Application number: 2025/90591	
What is the application for?:	Erection of two storey rear extension
Address of the site or building:	47, Butternab Road, Beaumont Park, Huddersfield, HD4 7AR
Postcode:	HD4 7AR

User comments

North East Elevation (Rear) 1.100

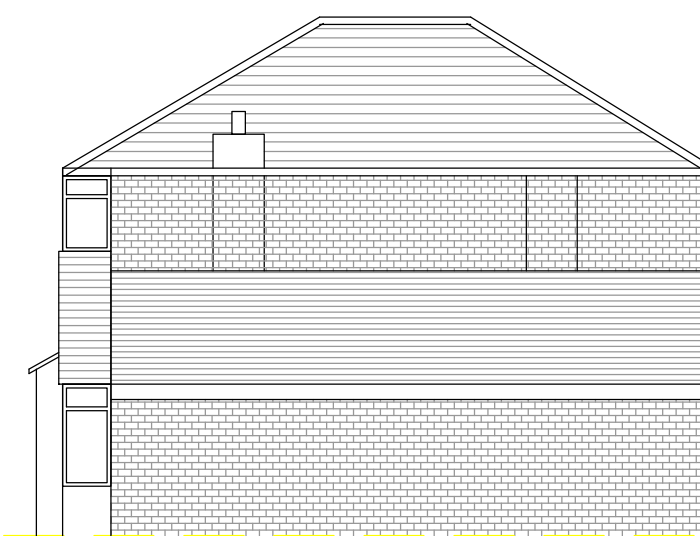
The upper & lower windows of the extension would overlook our rear garden and totally destroy our privacy and well being.

As you will have realised from our comments our main concern is the total loss of privacy and the extreme dominance we will feel with a proposed 2 storey extension.
